Your ref:  
Our ref: 23/02102/F  
Please ask for: Lynn-Marie Elliott  
Direct dial:  
E-mail: borough.planning@west-norfolk.gov.uk

Details: **PROPOSED SIDE EXTENSION FOLLOWING DEMOLITION OF SIDE PORCH (CURRENTLY USED AS UTILITY) AT 15 RAILWAY ROAD, DOWNHAM MARKET, PE38 9DX at 15 Railway Road Downham Market Norfolk PE38 9DX**

DRAWING NO.
230974 / 10 / 02

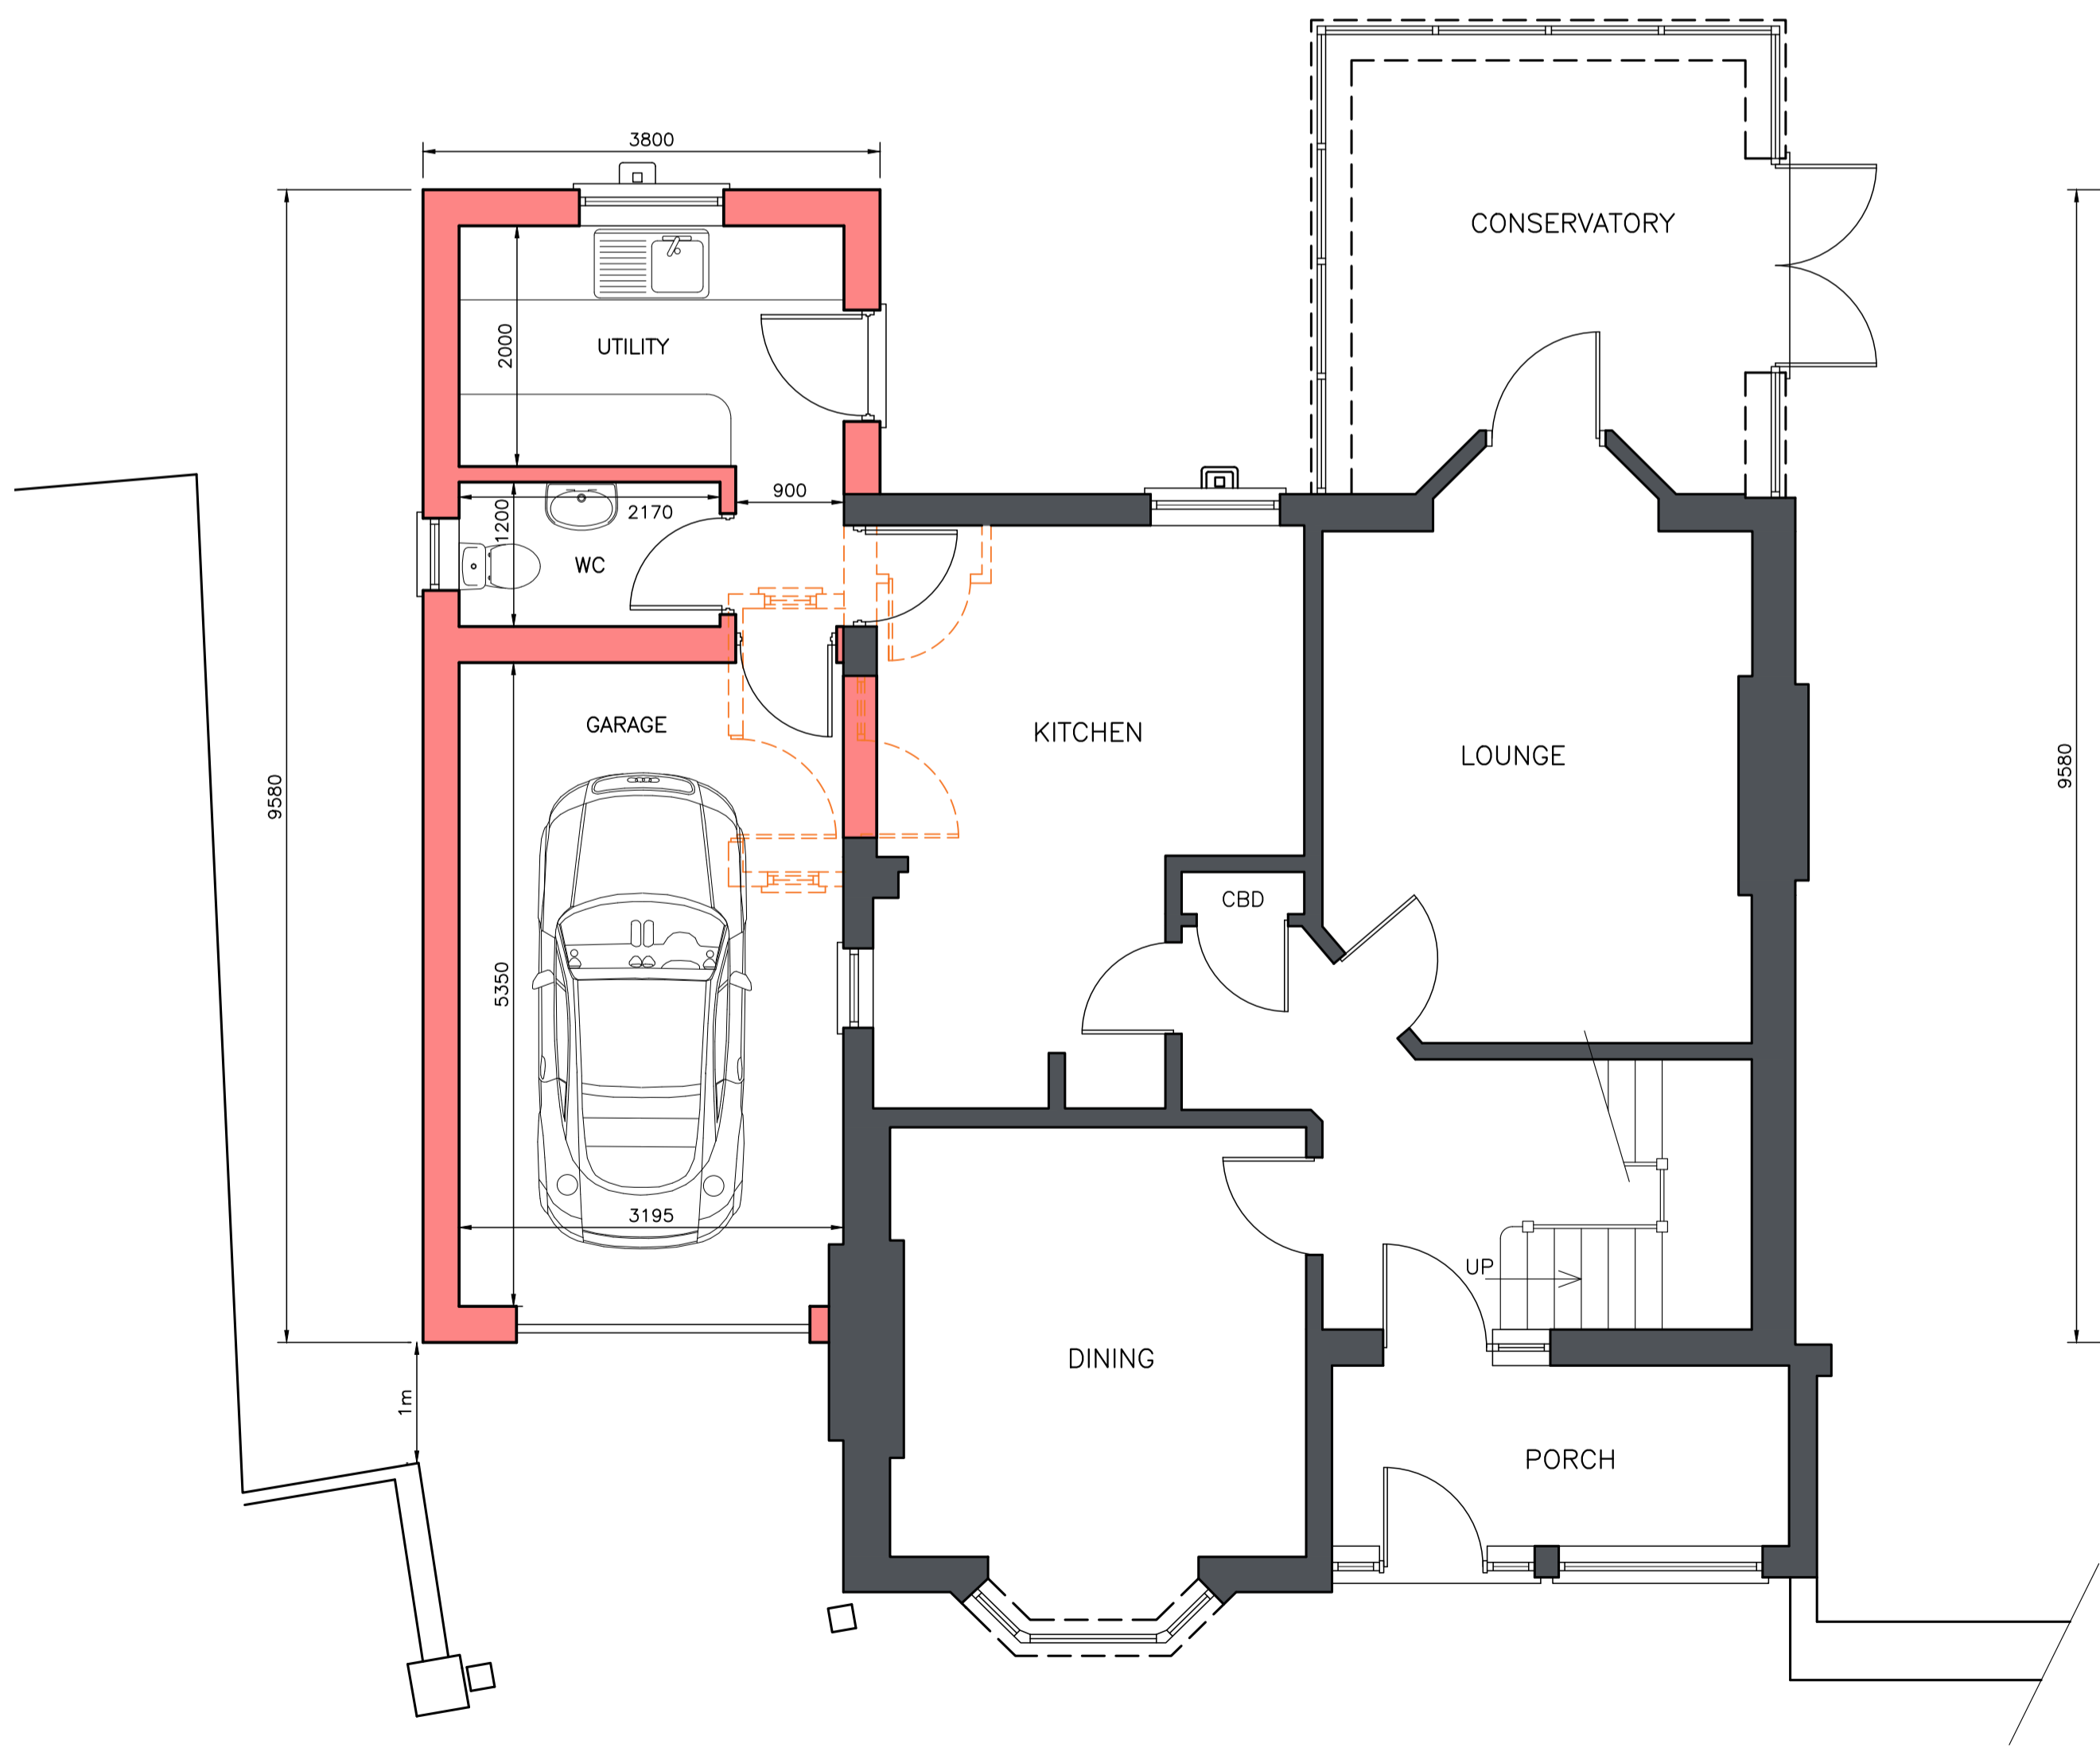
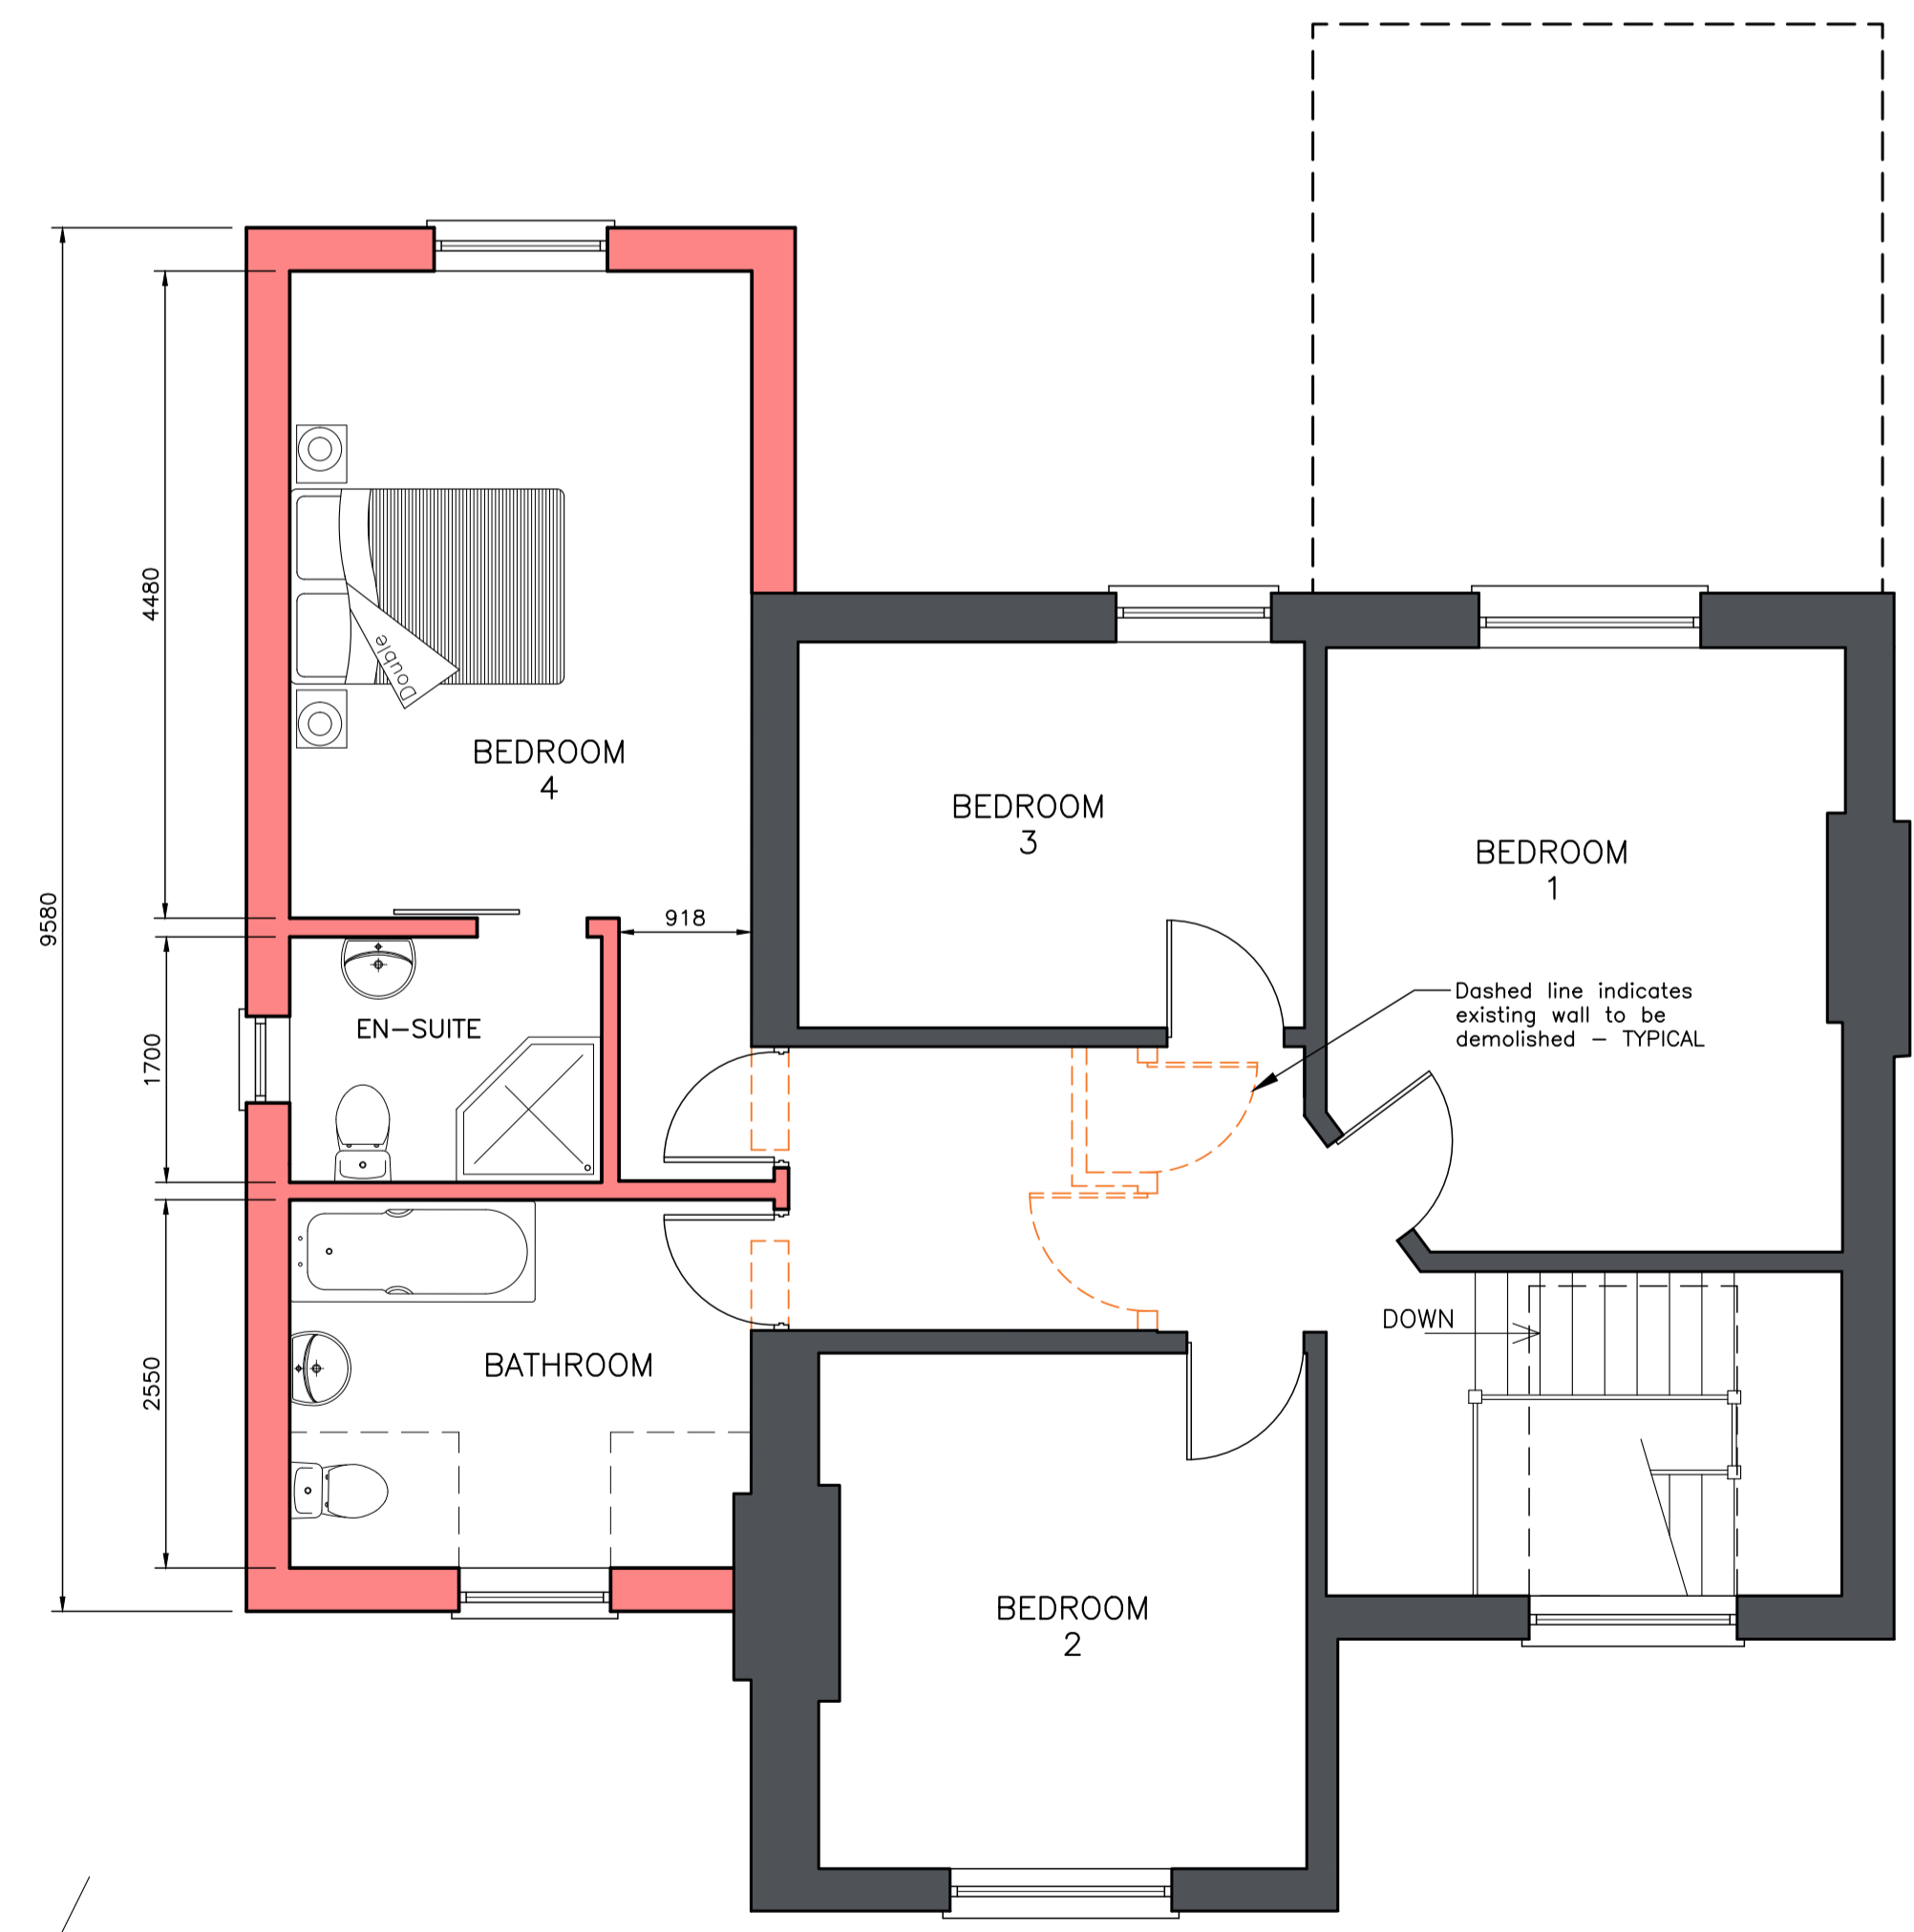
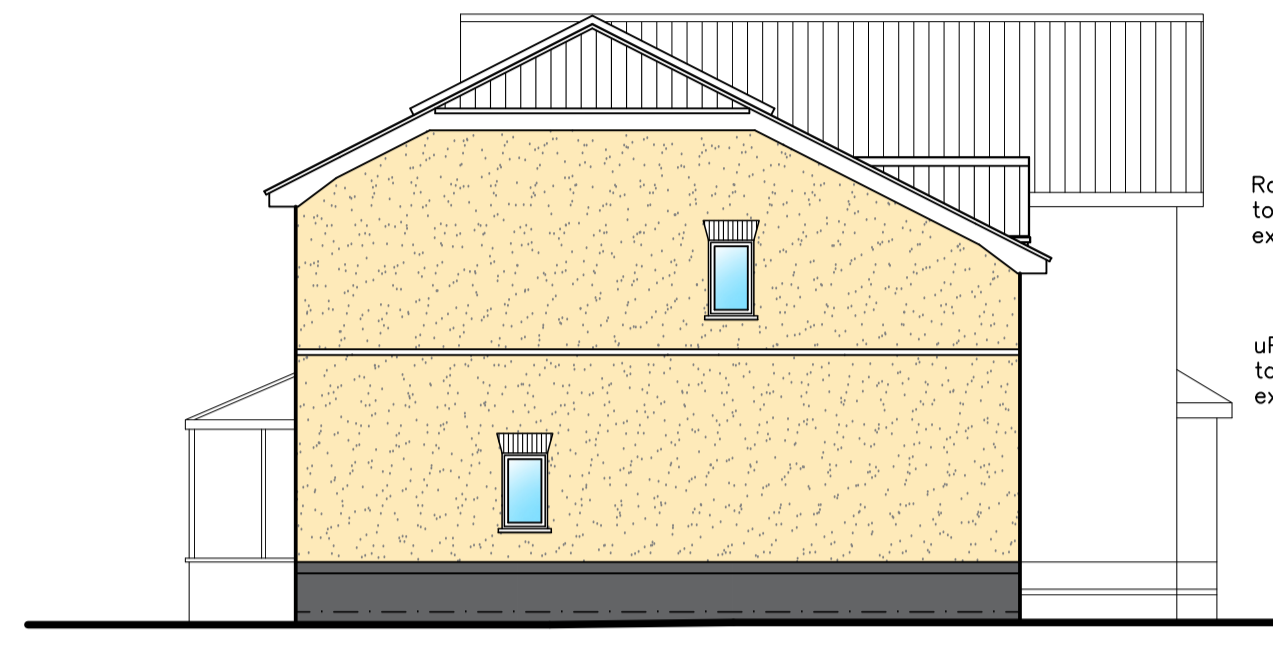
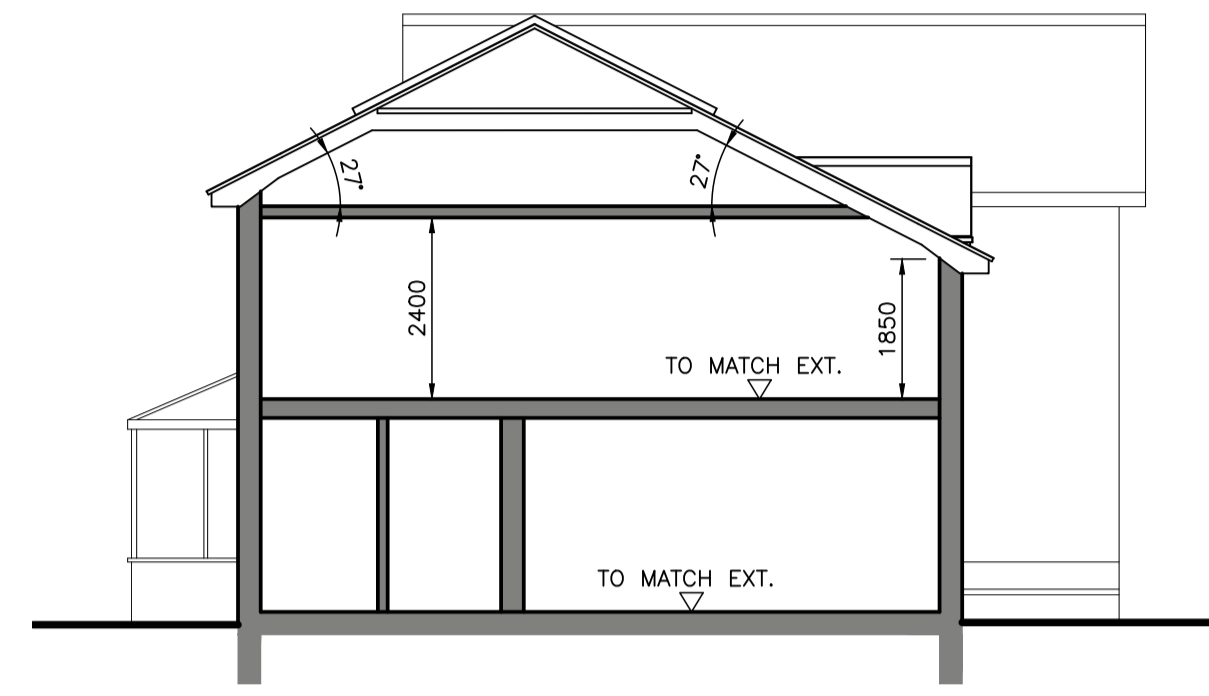
1. The annotation on the drawing(s) submitted with your application refers to the drawing being not to scale. Please remove any such reference for the purposes of the planning application.
2. Please can you check the scale as part of the site isn't measuring accurate.
